Appeal Decision

Appeal Ref: APP/R5510/W/23/3314637

1 Cheddar Waye, Hayes, Hillingdon UB4 0DZ

- The appeal is made under section 78 of the Town and Country Planning Act 1990 against a refusal to grant planning permission.
- The appeal is made by Mr A Saroe against the decision of the Council of the London Borough of Hillingdon.
- The application Ref 76544/APP/2022/1451, dated 5 May 2022, was refused by notice dated 15 July 2022.
- The development proposed is the erection of a new attached dwelling, single storey rear extension to both existing and new dwellings and creation of vehicular crossover.

Drawing No. RA1490/REV A/02

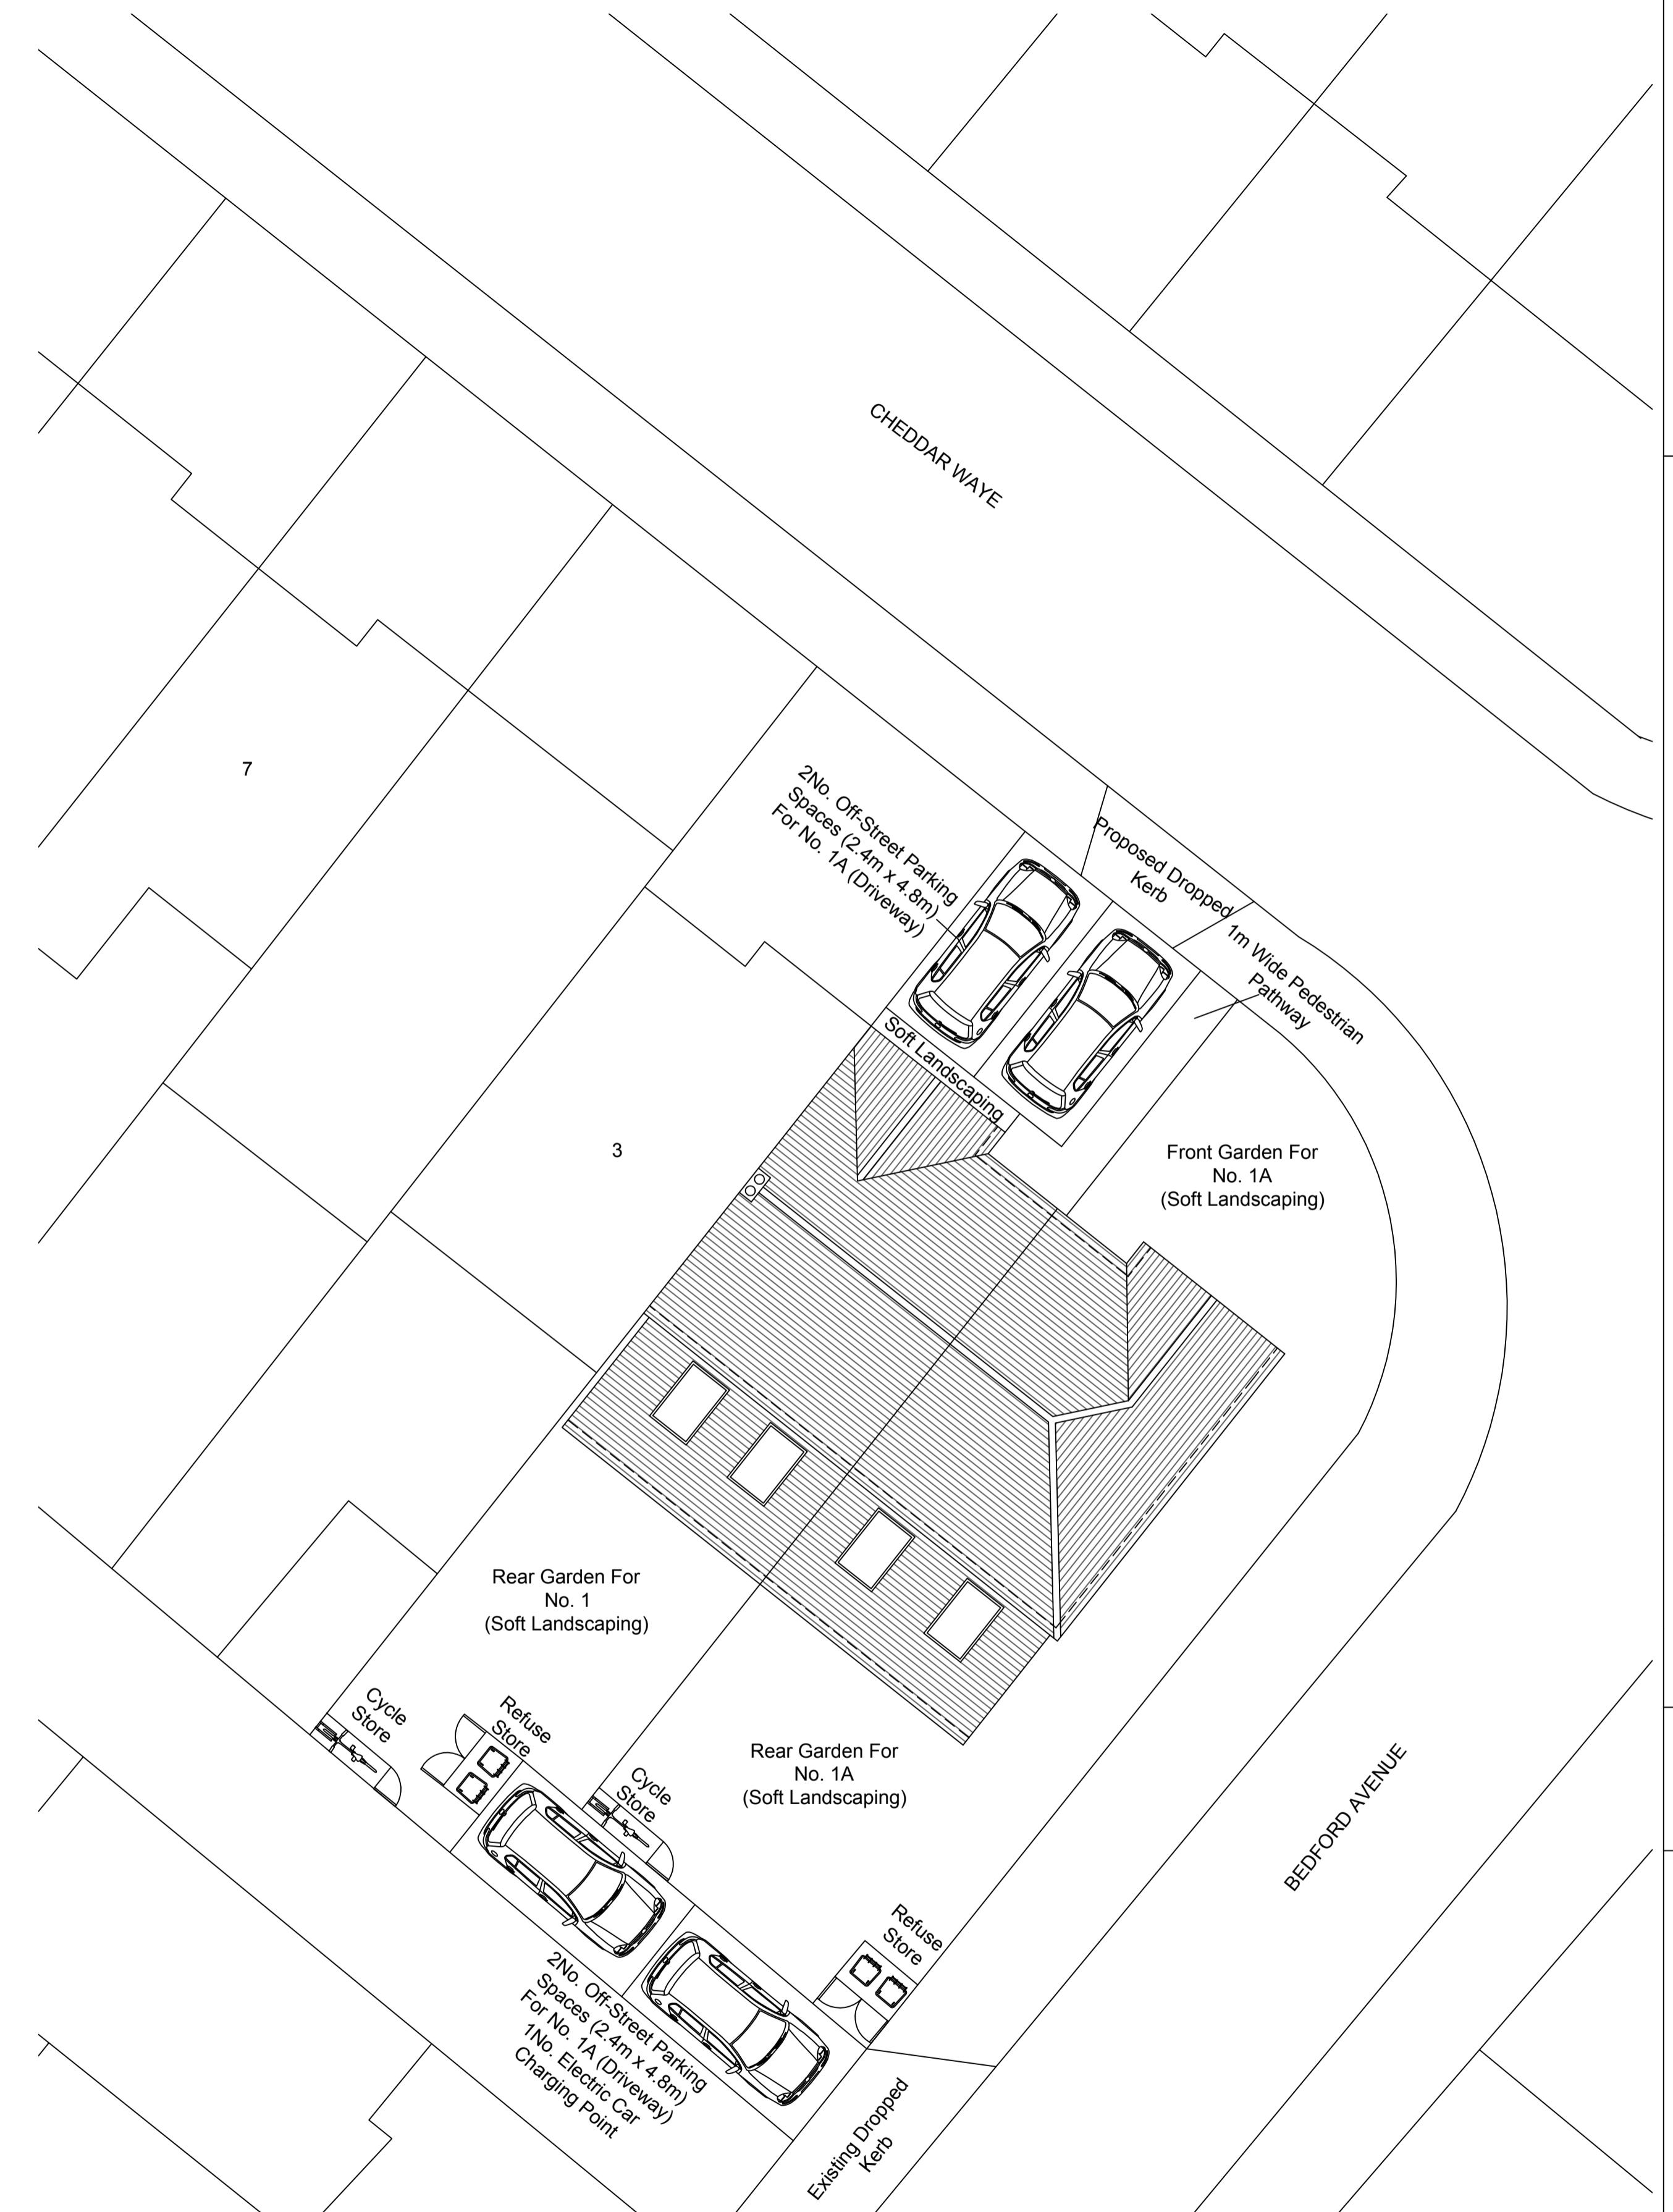
7. The cycle and refuse storage shown in the rear garden of the host property would only be accessible either through the house itself or via the driveway of the proposed house. Given that the driveway of the proposed house may ultimately be in different ownership, access across the driveway would not be guaranteed. Even if independent access were possible, there would be very little space to wheel a bike or a bin out to the public highway should a car be parked, due to the very constrained width of the driveway.

8. Based on the parking layout proposed for the host property, there is no evidence before me to suggest that there would be sufficient space to allow cycle and refuse storage to the front as a safer, more accessible alternative. This is due to the proposal showing that the car parking would occupy almost the entire hardstanding to the front of the house, leaving negligible space to dedicate to any storage. The appellant has offered their agreement to a condition requiring the relocation of the cycle and refuse storage to the front. However, I do not find that it would be reasonable to attach a condition requiring details of alternative cycle and refuse storage provision since this would likely require substantive changes to the proposed parking arrangements and layout, and that is not the scheme before me.

9. On the basis of the evidence provided, therefore, the cycle and refuse storage for the host property would harm the living conditions of future occupiers as it would be difficult or inconvenient to access due to its position within the rear garden. This would run contrary to the requirements of London Plan Policy D6 which aims to achieve high quality residential design, along with London Plan Policy T5 which sets standards for cycle parking and seeks to achieve safe, secure and accessible cycle storage.

Drawing No. RA1490/REV A/01

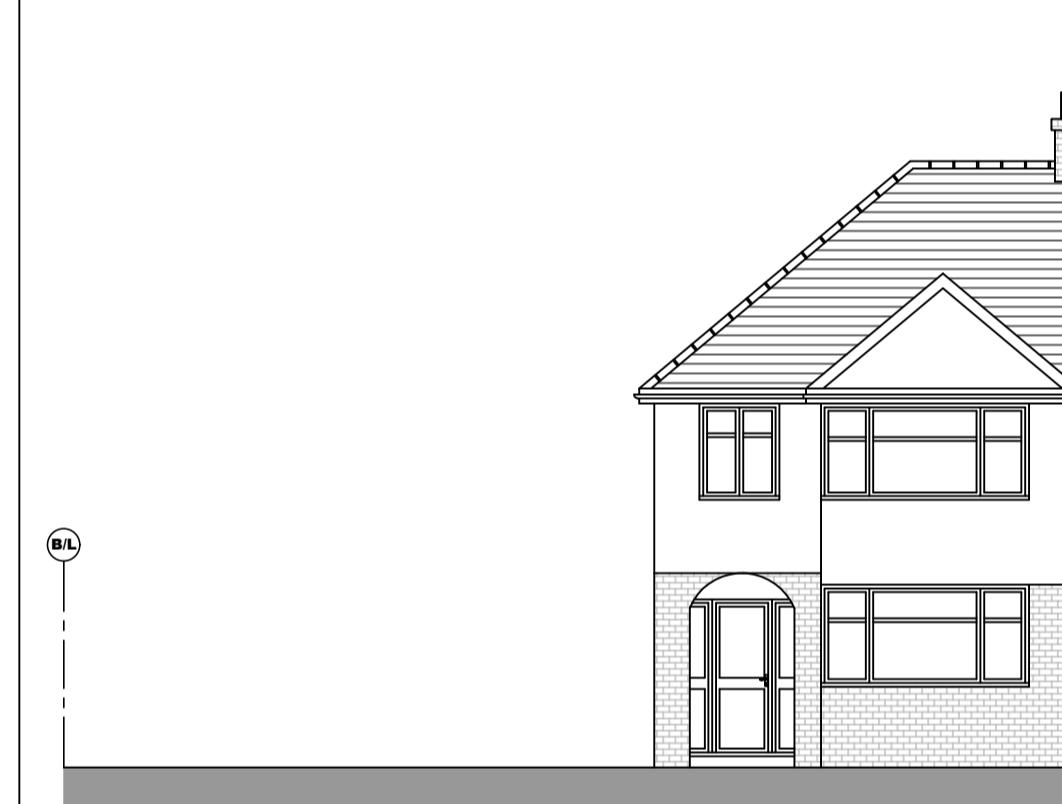
property would be below the 60 square metre requirement of Policy DMHB 18 of the Hillingdon Local Plan: Part Two – Development Management Policies 2020 (HLP 2020), it would still provide a functional garden space and would be commensurate with the plot widths, size and proportion of rear gardens along this side of Cheddar Waye; on balance it would be an acceptable standard.

6. Notwithstanding the disputed figures for the garden area to the proposed house, the combined rear, side and front garden areas would provide satisfactory outdoor amenity space and would provide appropriate living conditions for future occupiers and as such is appropriate in the context of Policies DHMB 11 and DHMB 18 of the HLP 2020. The absence of harm in this respect holds neutral weight in my consideration of the appeal.
